Roof alterations with raised roof ridge, first floor side extension and front and rear
dormer windows

12 Central Avenue Rustington

Thank you for your internet representation made on 13th March 2019 which has been
recorded as '**no objection**' with the comments as follows:

Proposed Side Elevation 1:100
North

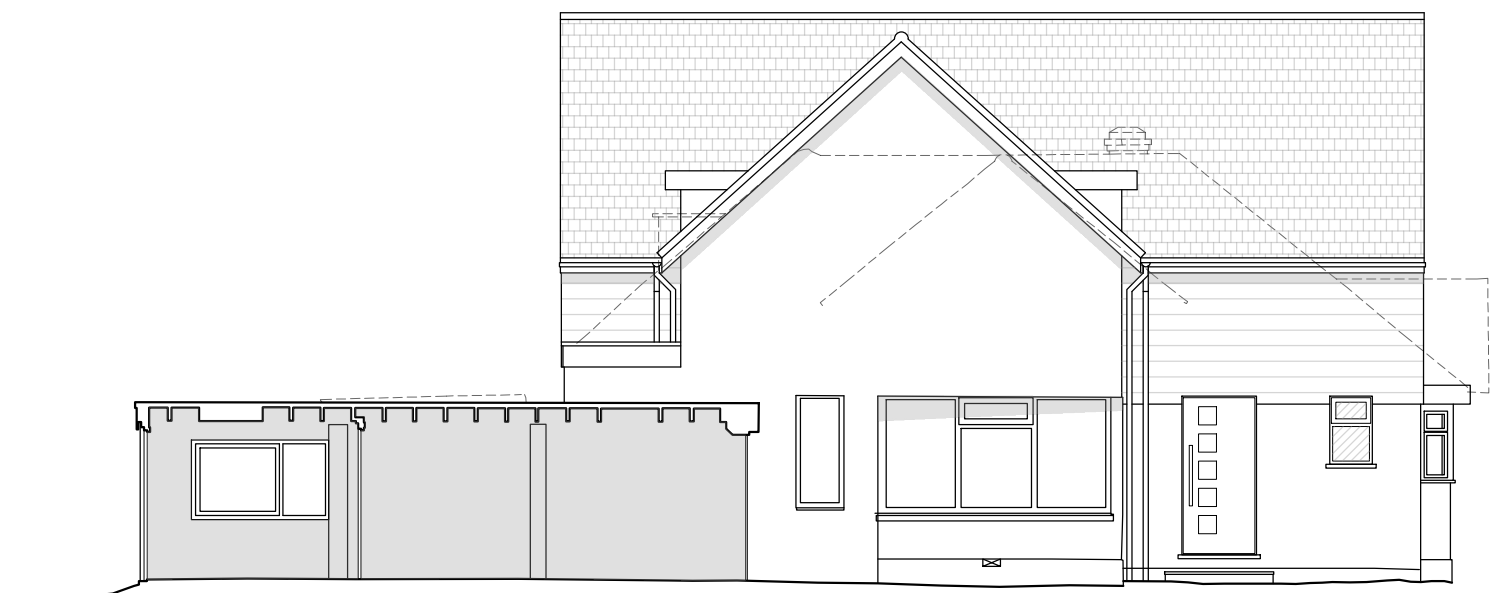
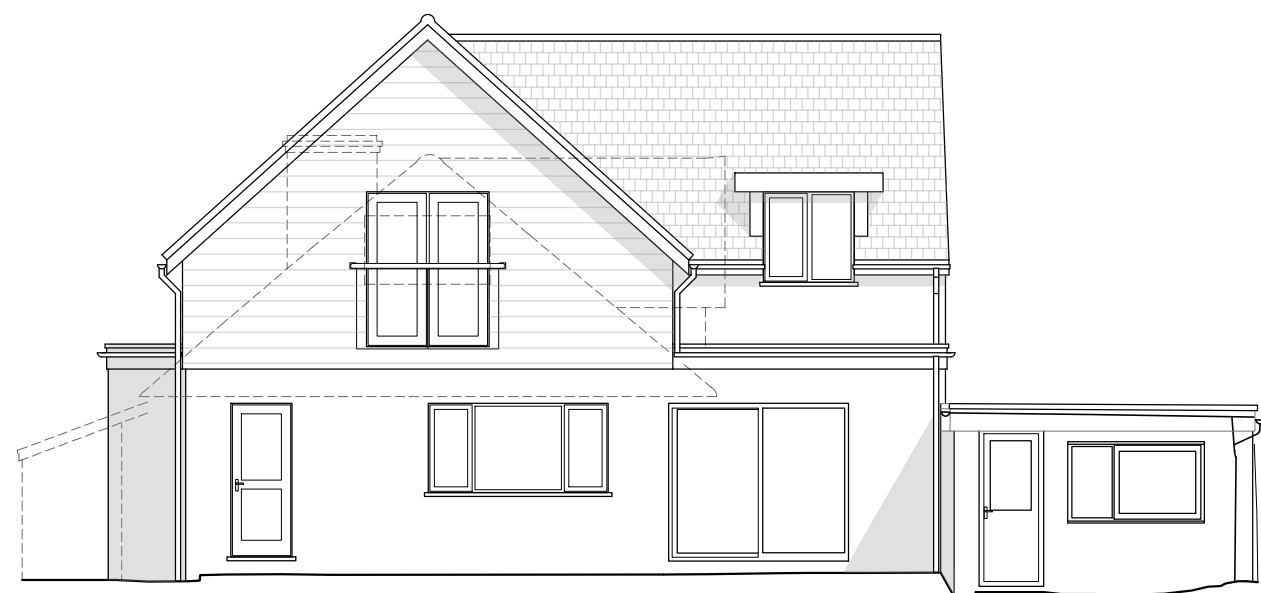
We wish to comment on the plan with regard to the proposed north side elevation. New windows are to be put into the first storey (apex) on this side which currently do not exist. We believe this will mean the occupants of No 12 will be able to look into our ground floor rooms which are a lounge and bedroom. Please note that both properties were originally bungalows and the new windows are, at the moment, for bathrooms. We request that a condition is put in that the windows on this side on the first storey are to have privacy glass regardless of use.
